Subject: RE: Planning Consultation on: Y/26/20/RES

Engineers comments on surface water drainage & land drainage;

APPLICATION NO: Y/26/20/RES

Site Address: Land at the Southern End of Cinders Lane Cinders Lane Yapton
BN18 0JJ

PLOT 16&17 | PLANS
DEVELOPMENT AT:
CINDERS LANE
YAPTON

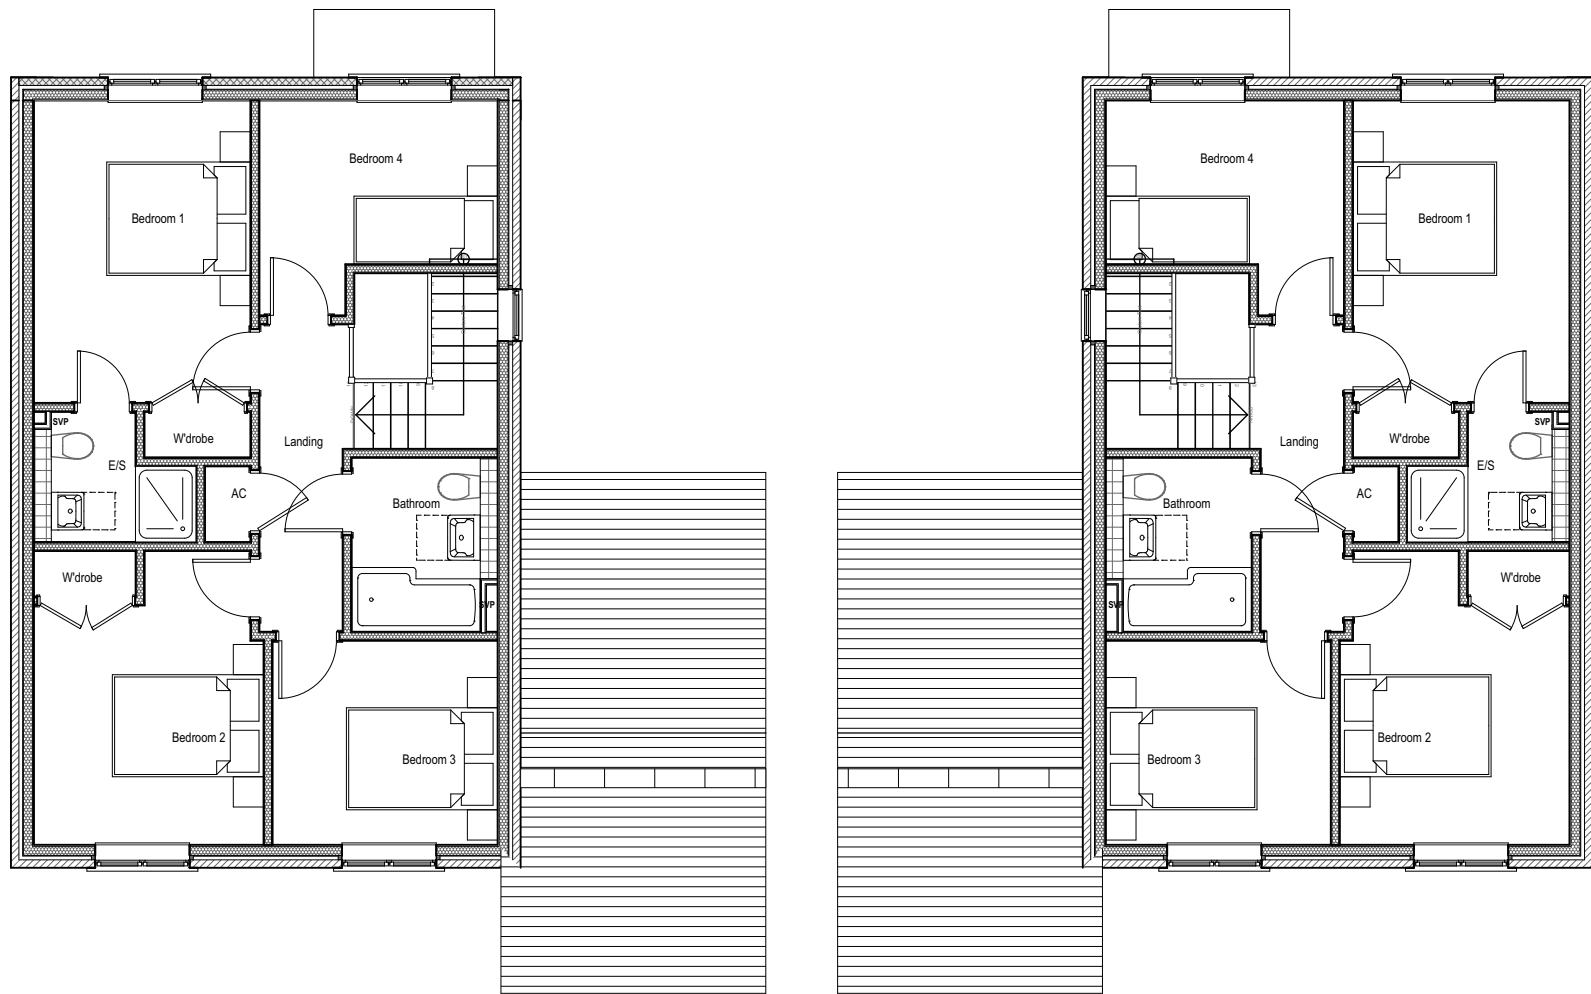
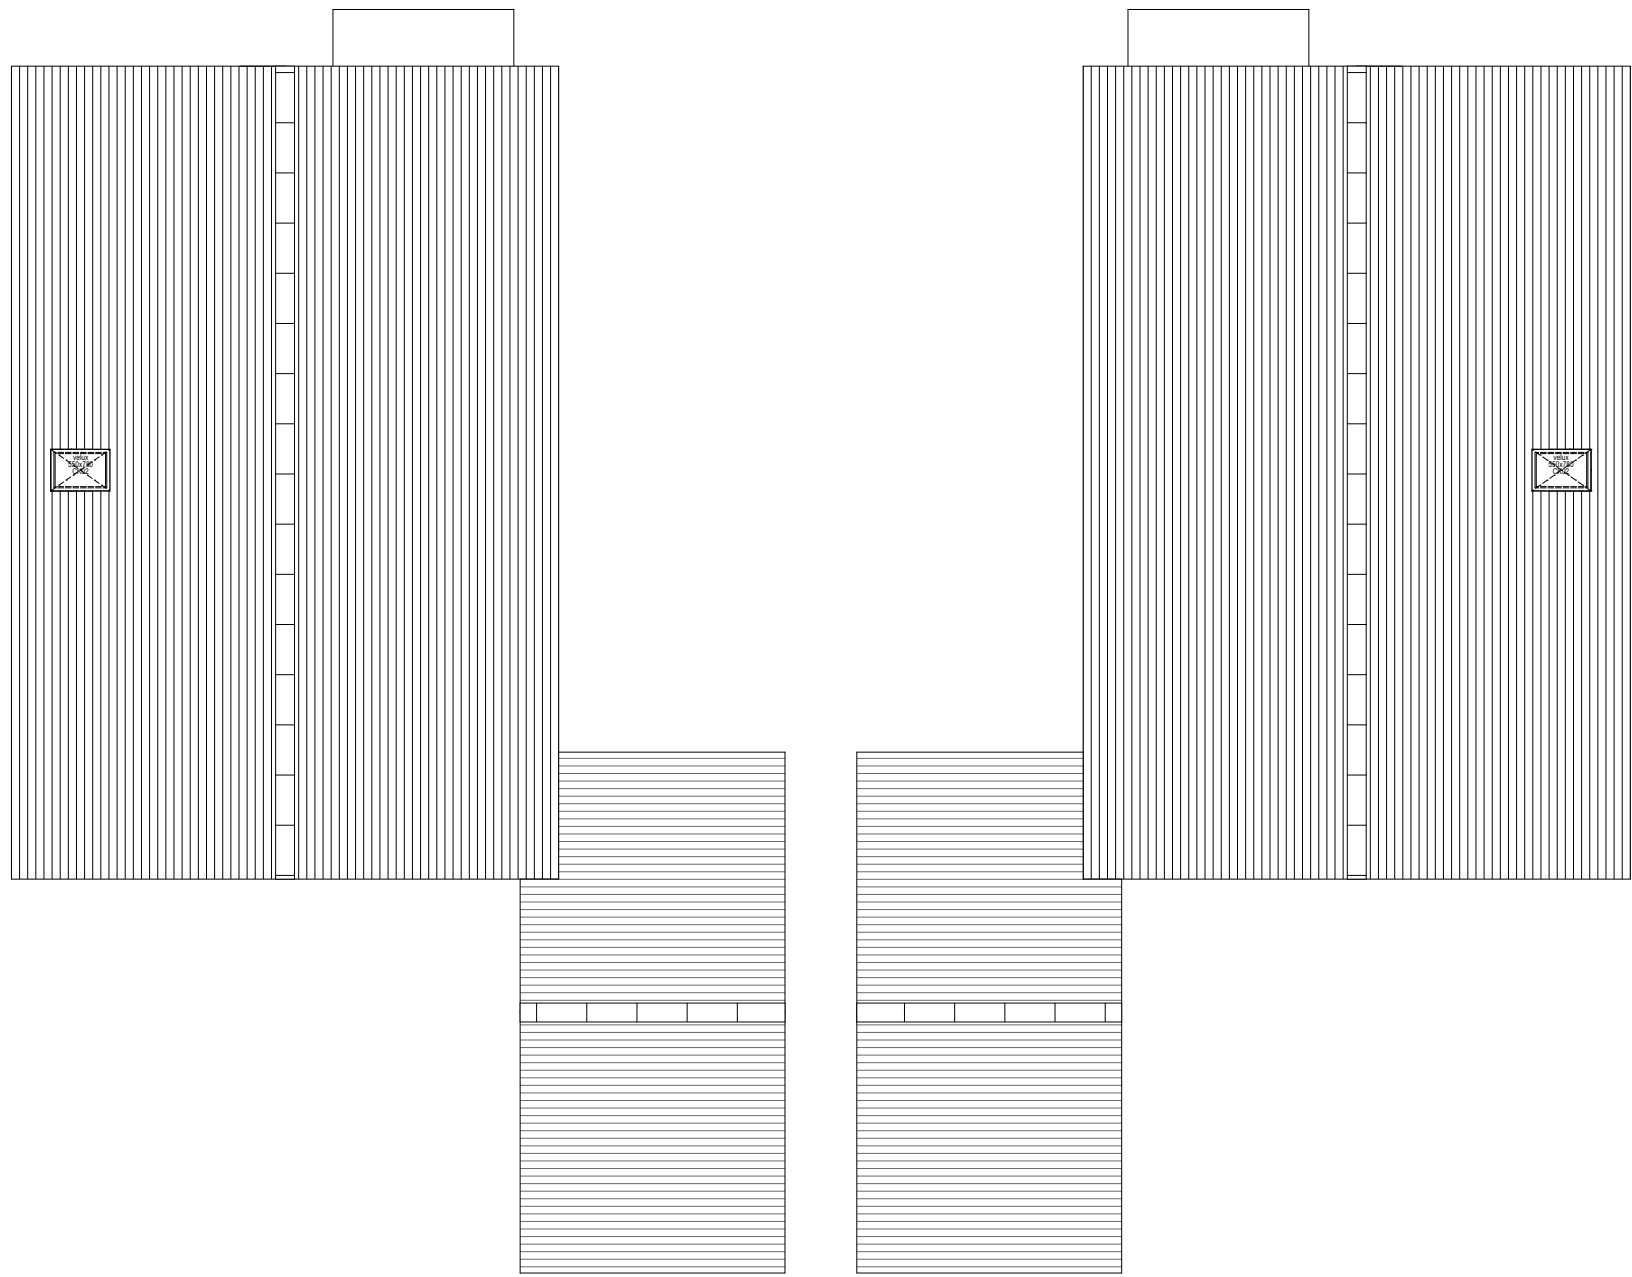
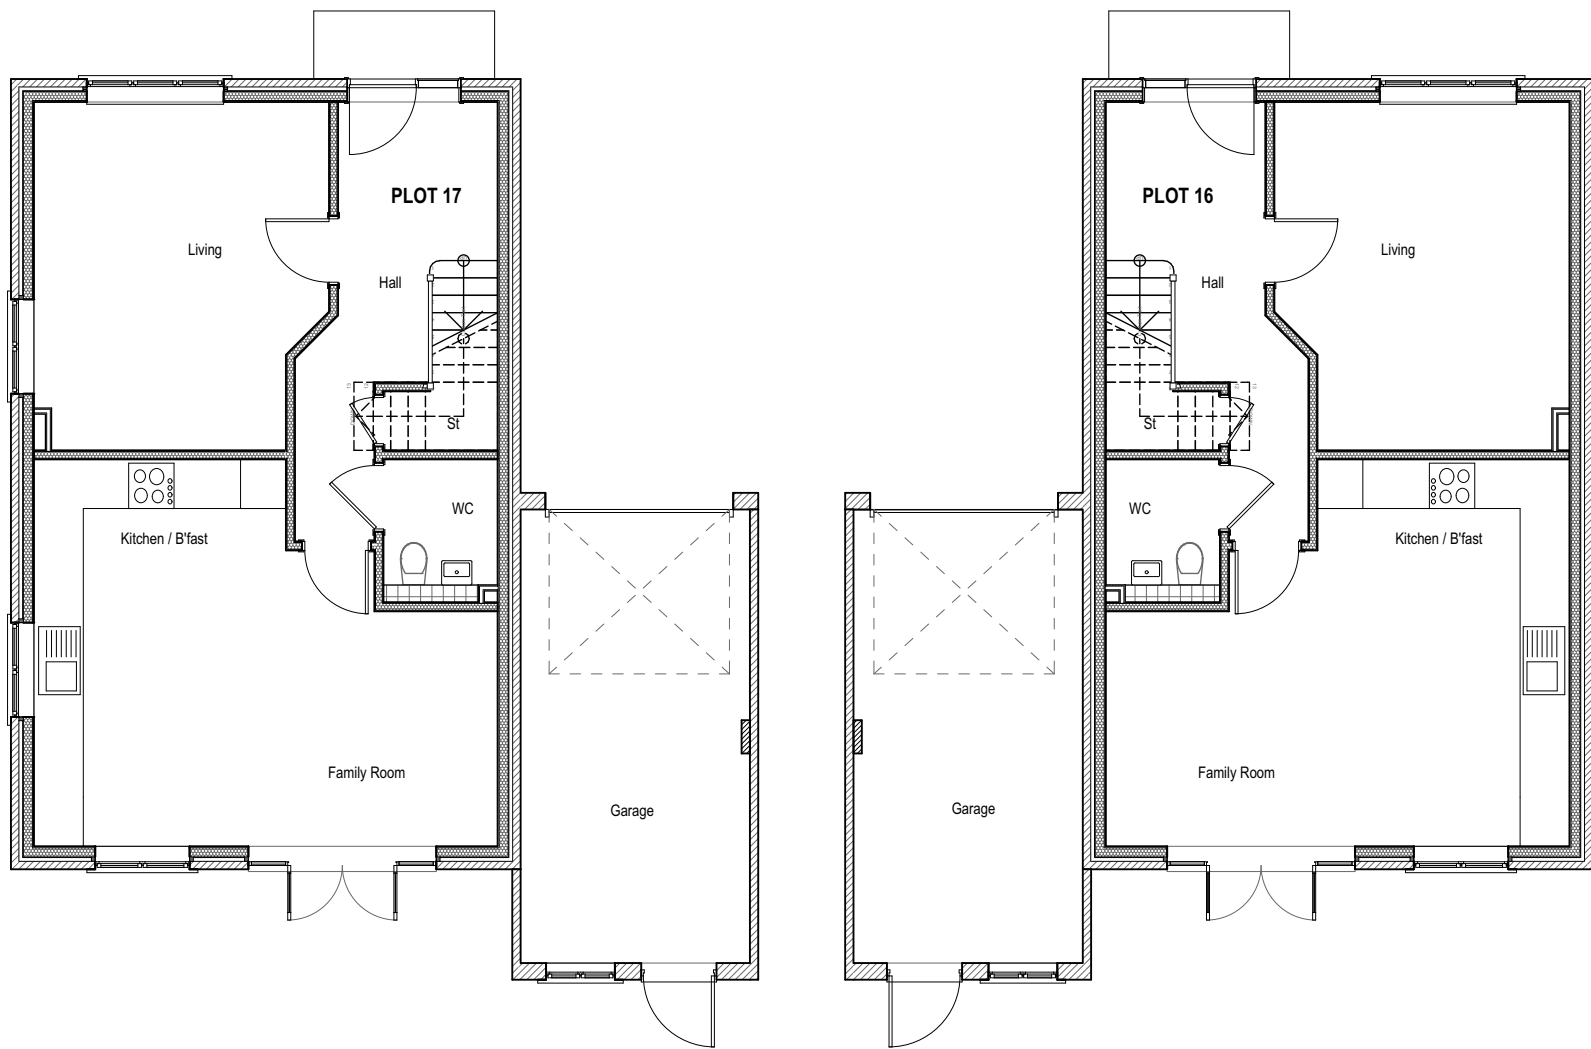
1. The conditions applied to Y/32/17OUT in respect to drainage are noted.
2. We are currently in discussion with the applicants engineers in respect to routing the existing ditch to the north through this development site, in order to re-establish the land drainage system in the area.
3. As a result of item 2, there may be a conflict between the potential boundary fencing of plot 17 which needs to be kept at least 3 metres from the top of the bank of the proposed ditch. This ditch may possibly also conflict with existing tree root protection zones. These discussions are still ongoing but note that the plot 17 layout could be impacted.
